**WELWYN HATFIELD BOROUGH COUNCIL
ASSISTANT DIRECTOR (PLANNING)**

DELEGATED APPLICATION

Application No: 6/2023/1340/HOUSE
Location: 4 Hook Lane Northaw Potters Bar Hertfordshire EN6 4DA
Proposal: Erection of single storey rear infill extension
Officer: Mrs Kerrie Charles

Recommendation: Granted

Title
PROPOSED PLANS

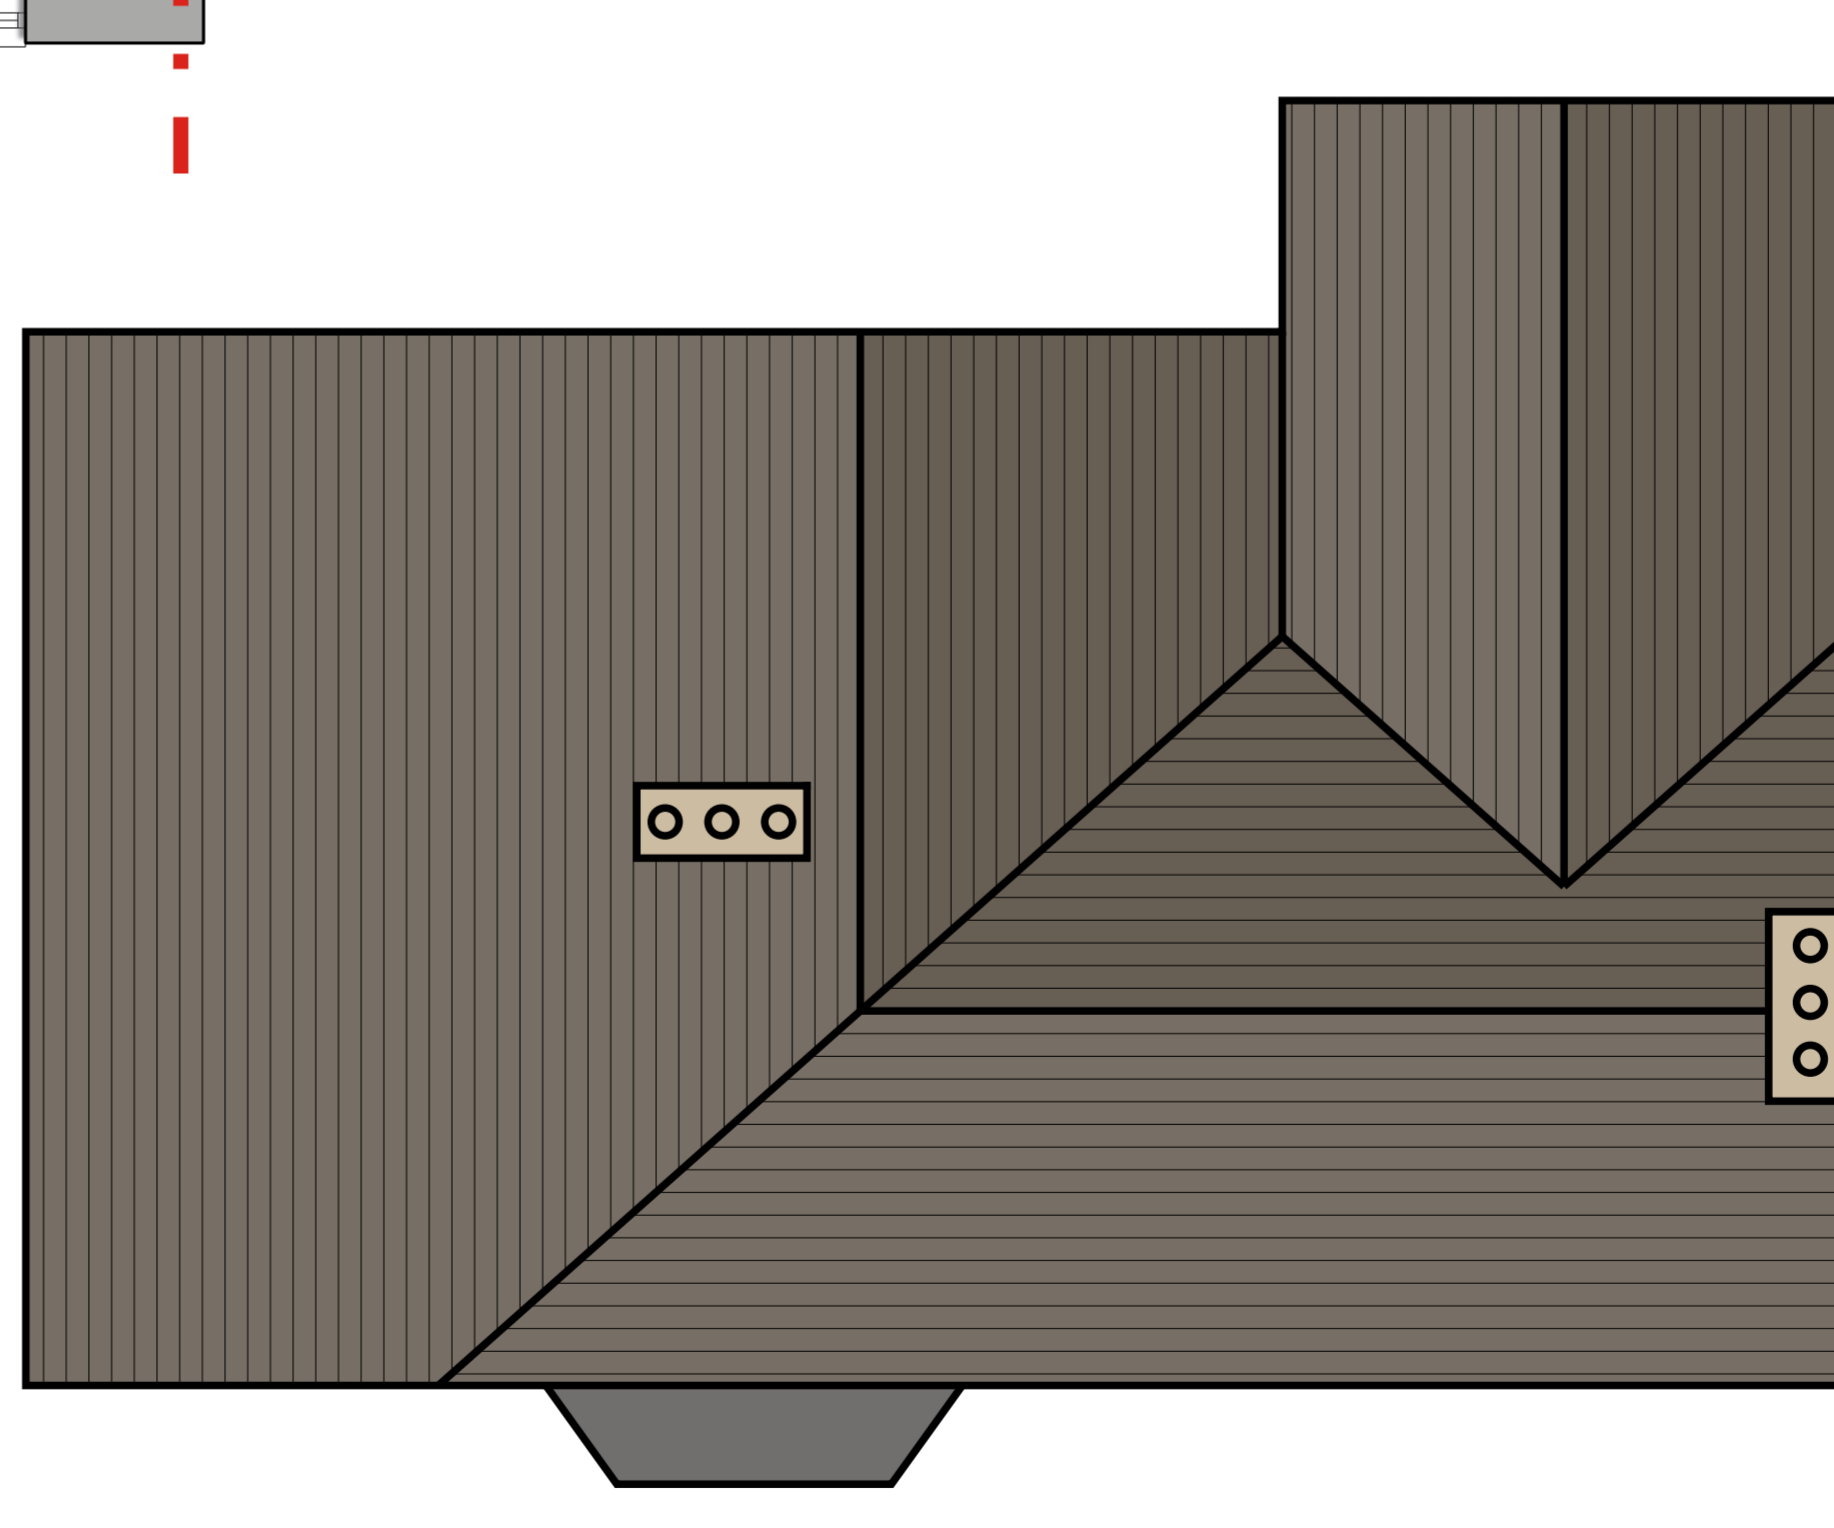
The proposed infill extension would amount to approximately 8.4 square metres of additional floor space. The percentage increase to the existing dwelling would equate to 28.45% and the dwelling would result in overall floor space of 148 square metres.

An increase of 28.45% of floorspace over and above the size of the existing dwelling in Green Belt land is not considered to result in a disproportionate increase in the original dwelling.

The addition, considered cumulatively, would not dominate the original dwelling and it is not considered that it would significantly alter its appearance or character.

Taking account of the above, it is considered that in regards to both its size and relationship with the original dwelling, the proposal would not result in disproportionate additions over and above the size of the original building. The proposal would therefore represent appropriate development in the Green Belt. The Courts have held that appropriate development is not harmful to Green Belt openness or the purposes of including land within it.

Title
PROPOSED ELEVATIONS

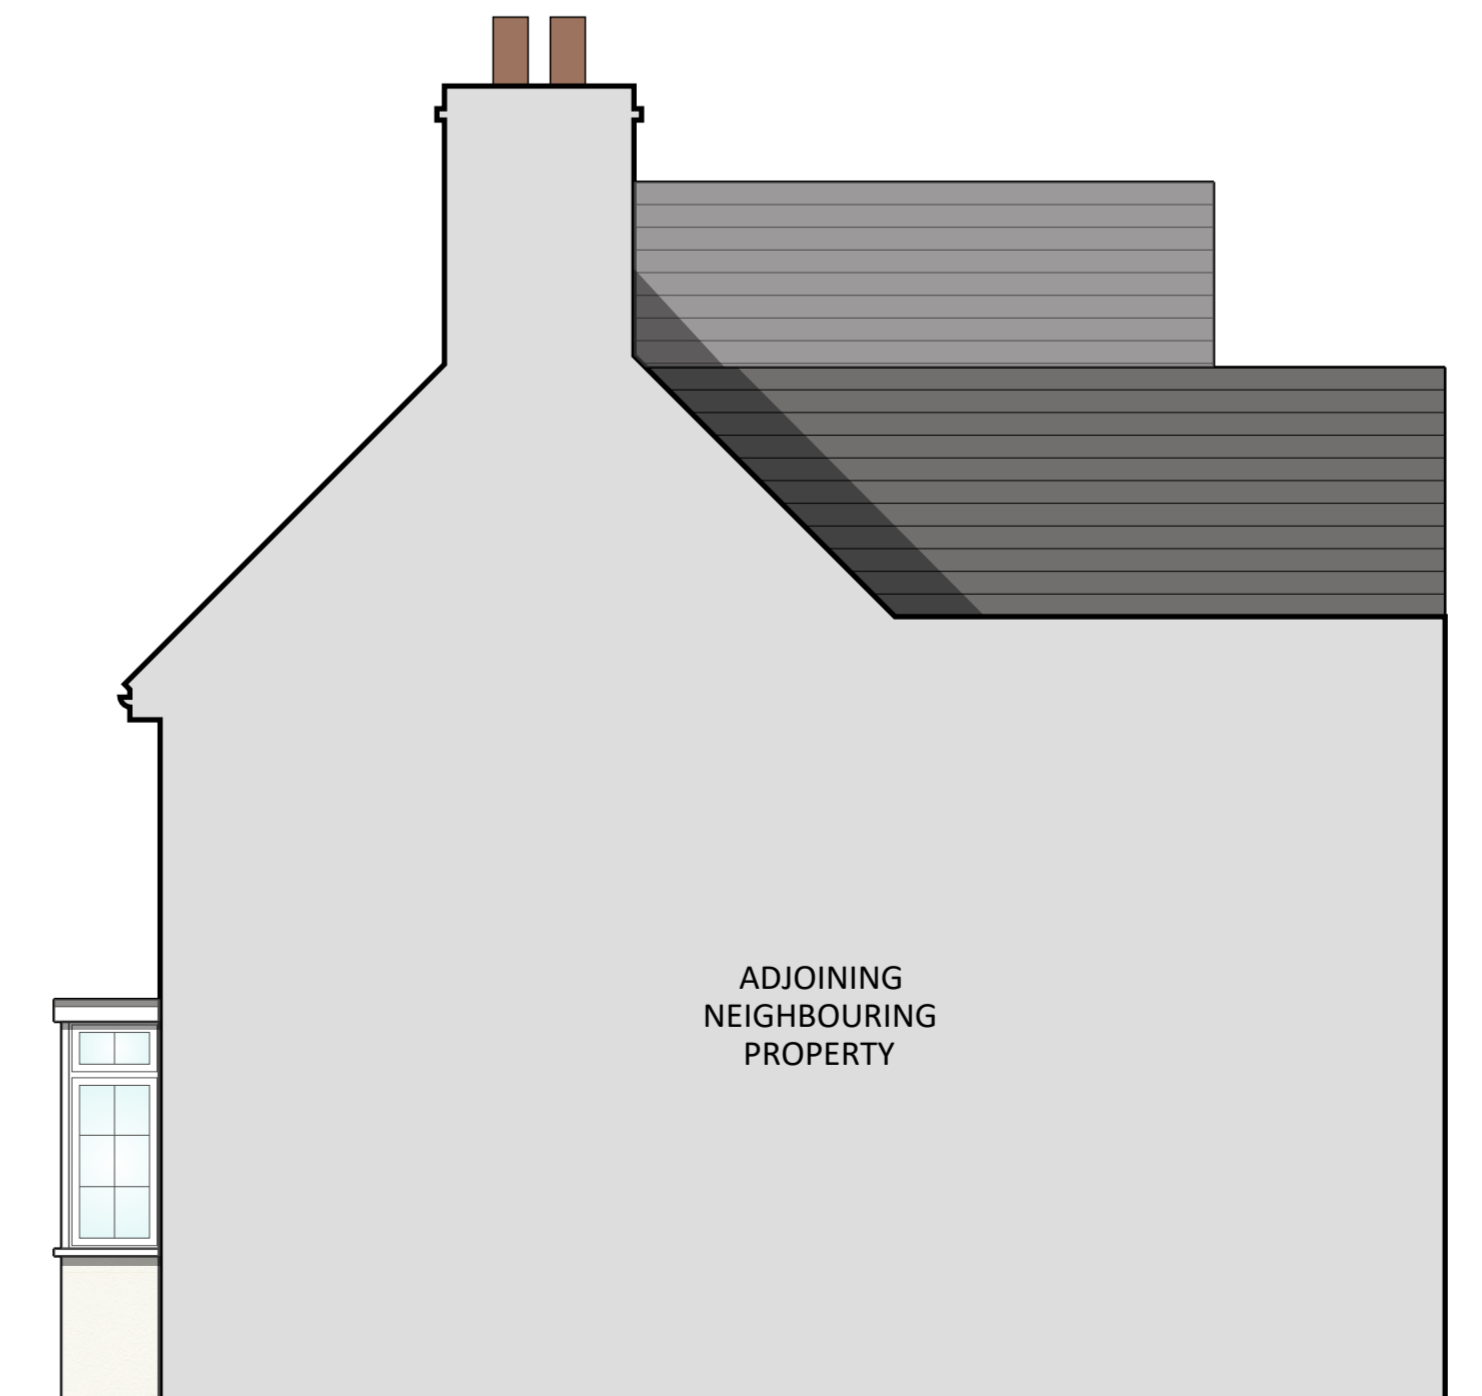
Comment (if applicable): The proposed extension would be located to behind an existing side extension and would not be prominent within the streetscene. The proposed design and materials relate well to the host dwelling and there is no conflict with Policies GBSP2, D1 and D2 of the adopted Welwyn Hatfield District Plan 2005 insofar as these seek to ensure that development is designed to a high quality, respects local character and context and therefore considered to sufficiently preserve the character and appearance of the property and is compatible with the character of Cuffley. The proposal further complies with the National Planning Policy Framework in terms of design and the Northaw and Cuffley Neighbourhood Plan 2023.
